Recommendation Report for Planning Permission for Works or Extension to a Dwelling

REF NO: BE/118/25/HH

LOCATION: 4 Violet Close
Bersted
PO21 5FS

PROPOSAL: Single storey side extension.

PROJECT	4 Violet Close PO21 5FS		CLIENT Gledhill	
	SHEET Ground Floor		Date Issue Date	Scale (@ A3) 1 : 100
		Drawn by SW	DRAWING NUMBER P 1	
		Checked by SR	REV

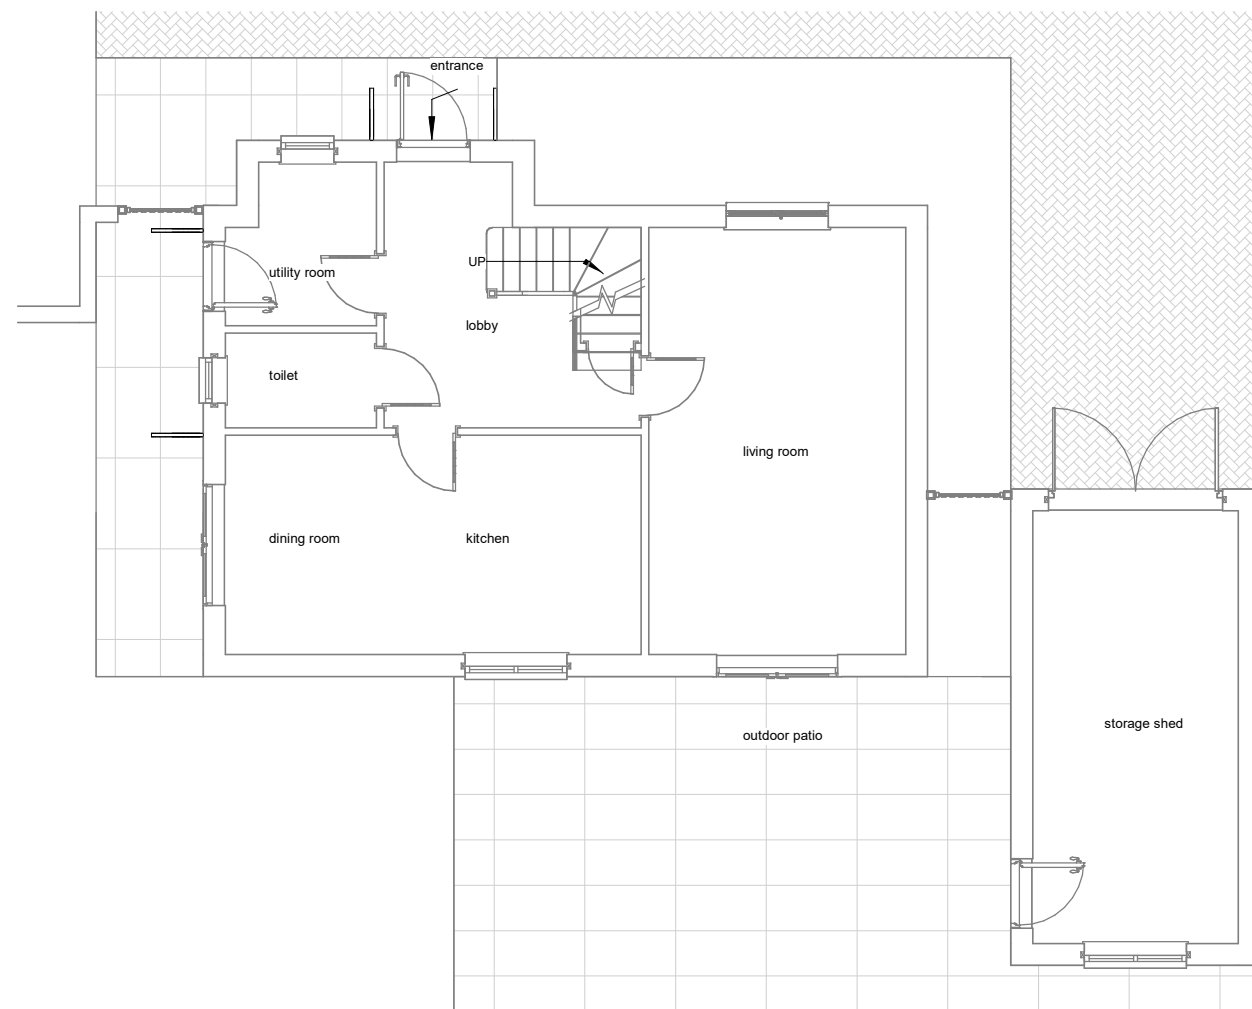
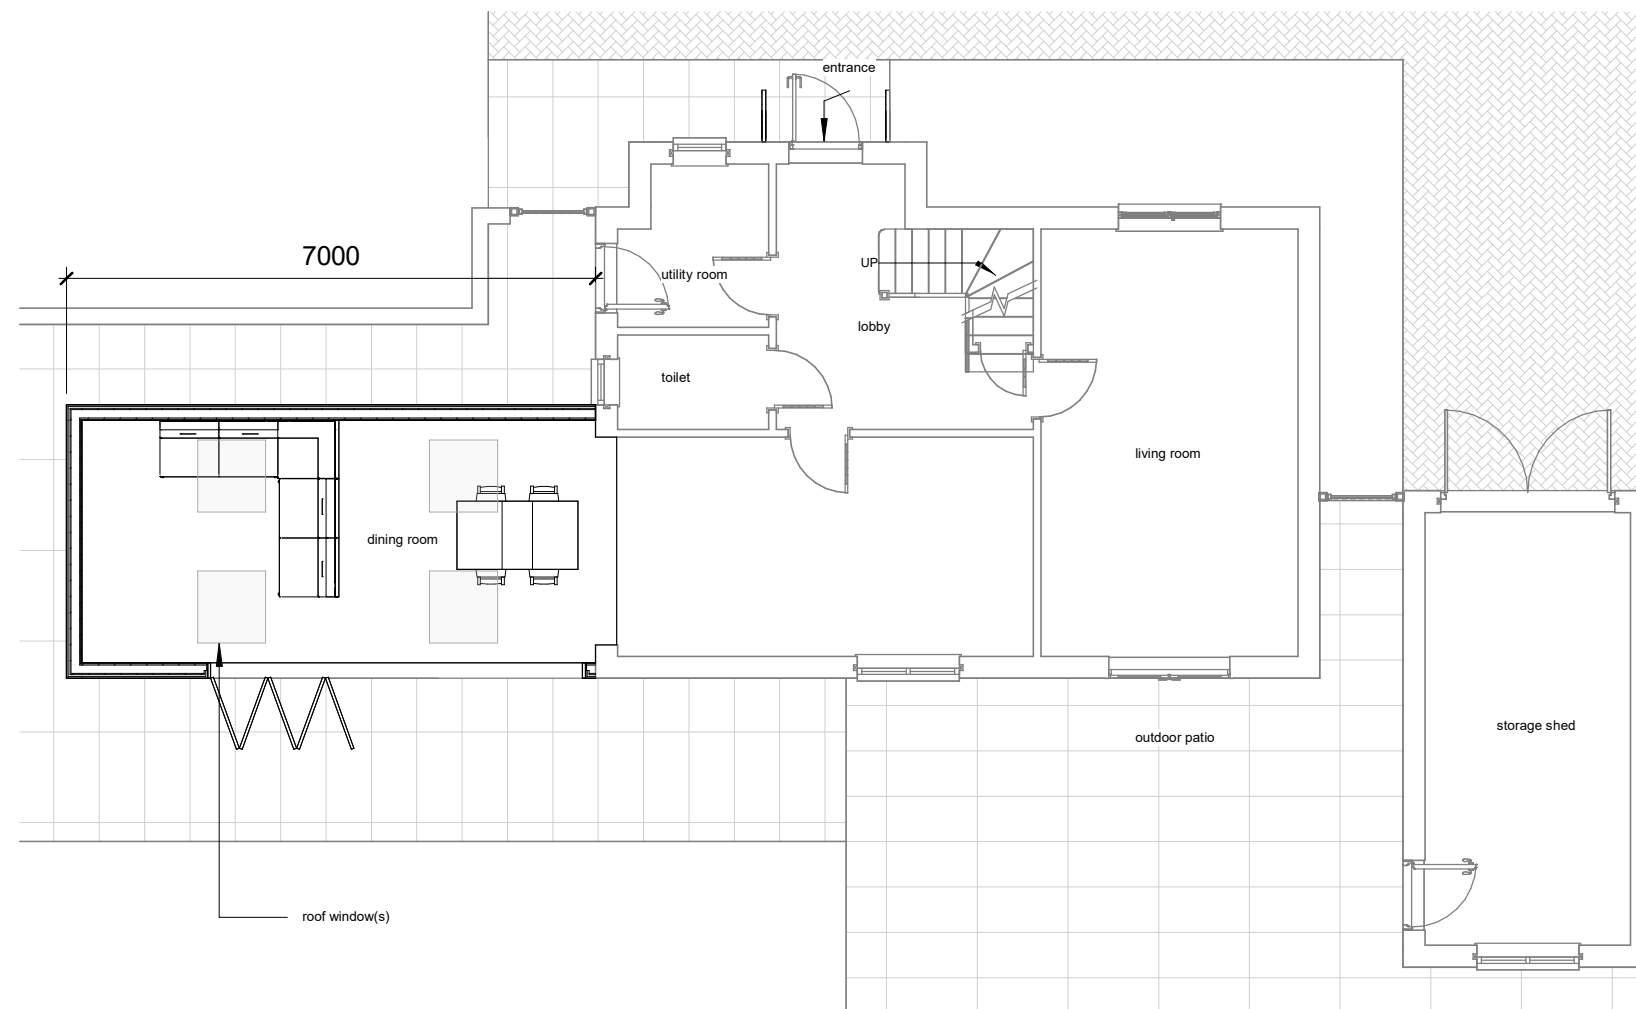
The single storey side extension would measure 7m in width, 3.6m in depth and would have a pitched roof with a maximum height of 4.5 and an eaves height of 2.7m. The additional width would be more than half the width of the existing dwelling and thus would not be subservient addition, partially conflicting with policy D DM4 of the Arun Local Plan (ALP). However, the extension would have a pitched roof form, reflecting the character and appearance of the host dwelling and the extension would be set back 2.5m from the front elevation of the host dwelling. The extension would be finished in brickwork and cladding to match the host dwelling. Therefore, the proposed extension would not appear unduly prominent within the street scene, nor would it result in harm to the character or appearance of the host dwelling, street scene or wider area and is acceptable in this instance.

The proposed extension would extend the built form closer to the neighbouring property to the northern side. However, a flank-to-flank distance of 8.4m would be maintained, with two driveways separating the dwellings which would mitigate any overbearing or overshadowing impacts to this neighbour. As such, the proposed side extension would not appear overbearing or result in any overshadowing to neighbouring properties.

|         |                            | Drawn by<br>SW   | DRAWING NUMBER<br>P 4 | REV                     |

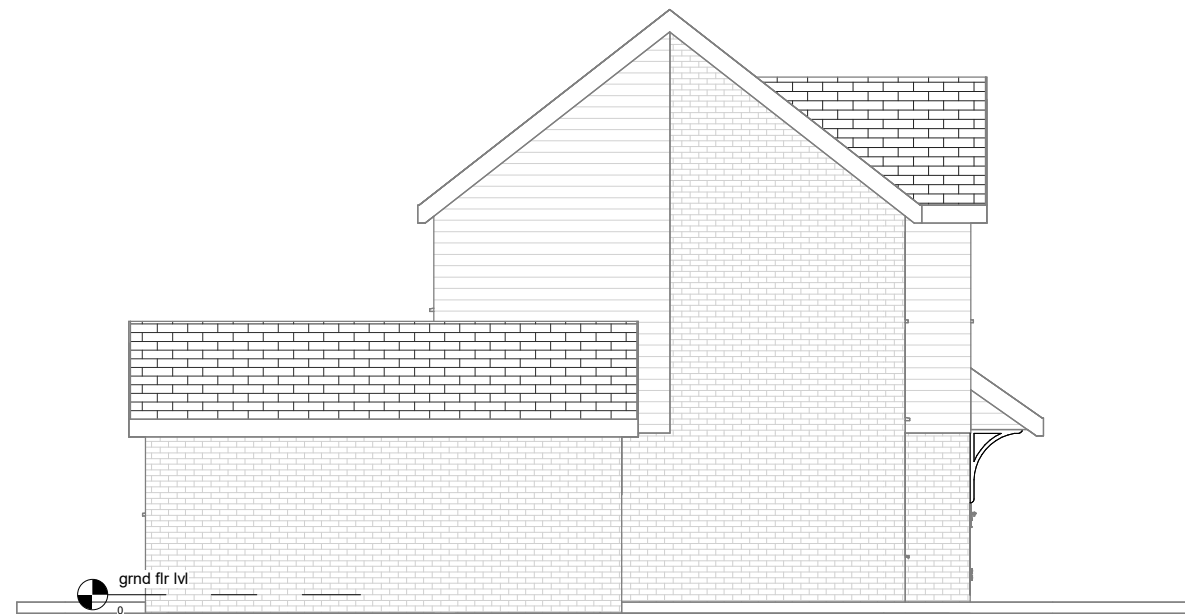
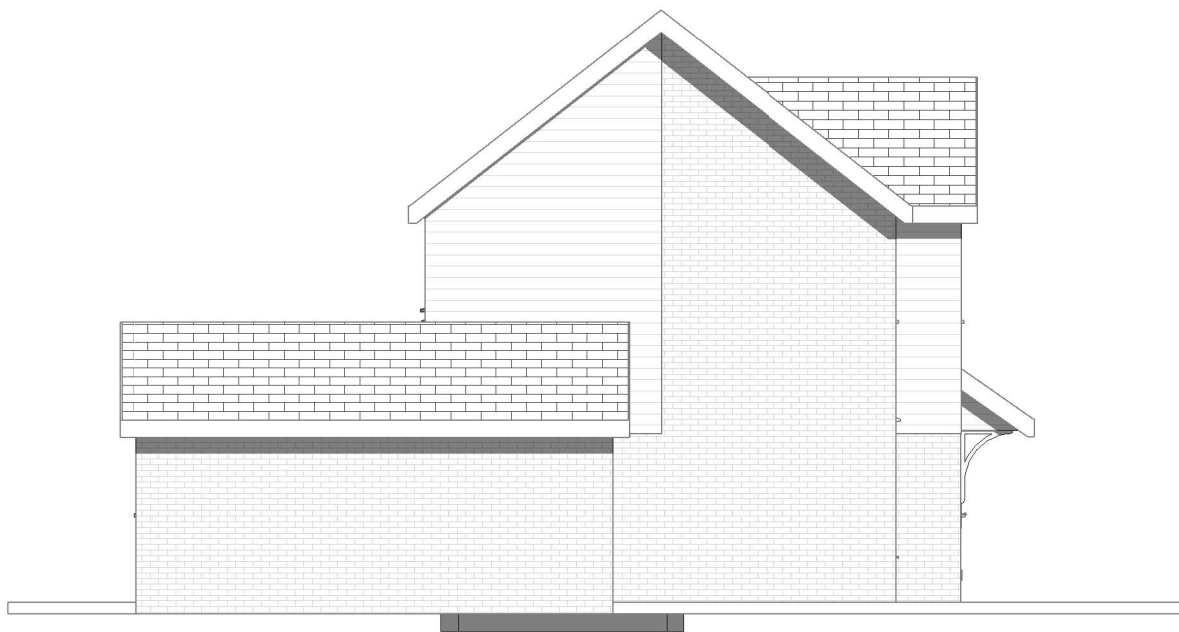
Two rooflights are proposed on each roof slope of the extension. The rooflights would be in accordance with Part M of the Arun Design Guide (ADG) as they maintain the privacy of the neighbouring properties and are used discreetly.

The western elevation of the extension proposes bifold doors which would provide an outlook to the rear garden and would not result in significantly different views achieved from the existing ground floor windows on this elevation. The rooflights are high level and would not lead to any overlooking impact. No other fenestration is proposed, therefore the extension would not result in any increased overlooking effects.
